Rezoning Transportation Analysis

Petition Number: 2023-042

Date	Description
07-26-23	First Review (PM)
08-23-23	Second Review (PDM)
11-27-23	Third Review (JP)
12-20-23	Fourth Review (JP)
03-20-24	Fifth Review (JP)
04-02-24	Trip Generation Update v1
04-15-24	Trip Generation Update v2
04-23-24	Sixth Review (JP)

REZONING PLAN

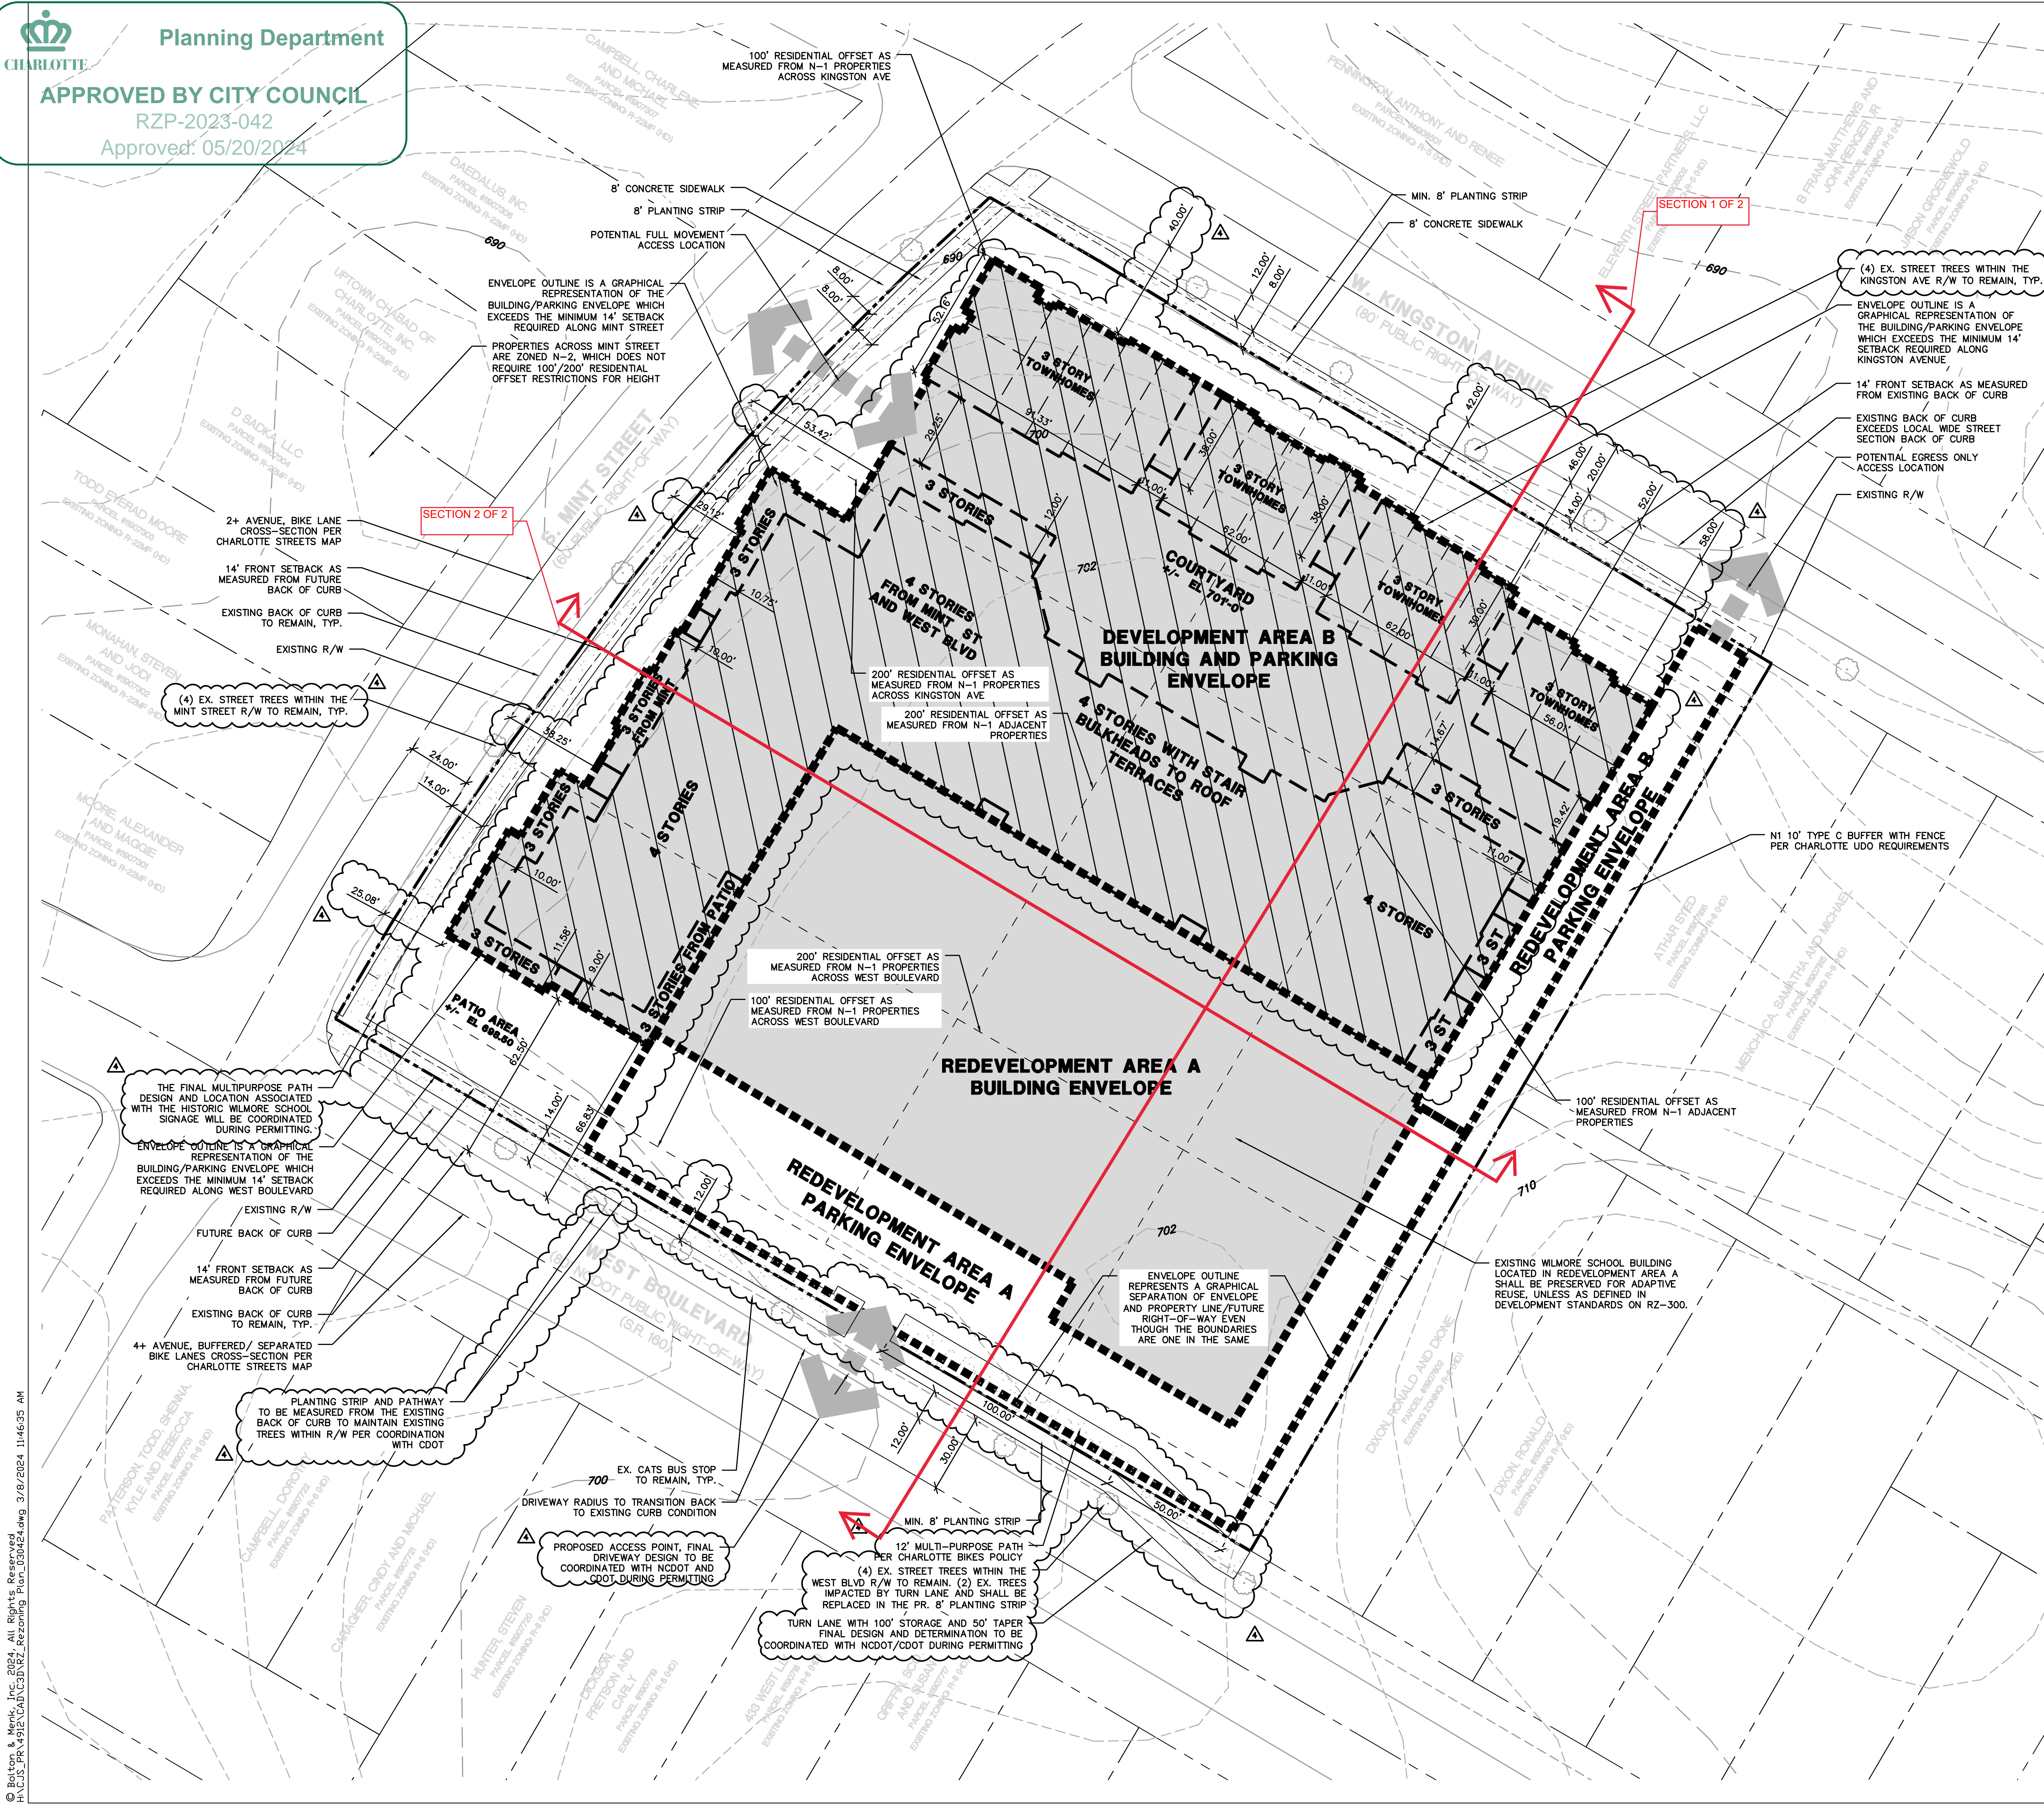
Label and dimension the future curb and gutter location from the centerline for each road on the site plan.

4. ~~Outstanding Comment from 7.26.23:~~ In coordination with NCDOT, revise site plan and conditional note(s) to commit to construct bicycle facilities by installing a 12' multi-use path on West Boulevard to meet the Council-adopted Charlotte BIKES Policy. Charlotte Streets Map calls for buffered bike lanes, NCDOT will not allow buffered bike lanes on West Boulevard. Multi-use paths maintained by the City shall meet ADA/PROWAG requirements.

~~Clarifying Comment from 11.27.23:~~ Proposed streetscape is only 8'. Due to NCDOT not wanting a bike lane on their street, this needs to be a 12' shared use path.

~~Clarifying Comment from 12.21.23:~~ Revise proposed streetscape to a 12' multi-use path to support council-adopted Charlotte BIKES policy.

5. ~~Outstanding Comment from 7.26.23:~~ Revise site plan to install the proposed streetscape off the future back of curb located 30' from the centerline.

7. ~~Outstanding Comment from 7.26.23:~~ Per coordination with NCDOT, the site access on West Boulevard needs to be right in ONLY with a right turn lane.

~~Clarifying Comment 11.27.23:~~ Revise site plane and conditional note to read, "Potential future driveway. Further coordination with NCDOT during permitting."

~~Clarifying Comment 12.20.23:~~ Although this is an existing driveway, NCDOT has the authority to remove or limit access. Add statement to callout and conditional note that approval of West Boulevard driveway will be coordinated during permitting.

8. ~~Outstanding Comment from 7.26.23:~~ Per coordination with NCDOT, remove this site access along West Boulevard.

9. ~~New Comment 3.20.24:~~ Show a proposed 12' ramp to match the shared use path width (ADA/PROWAG requirement).
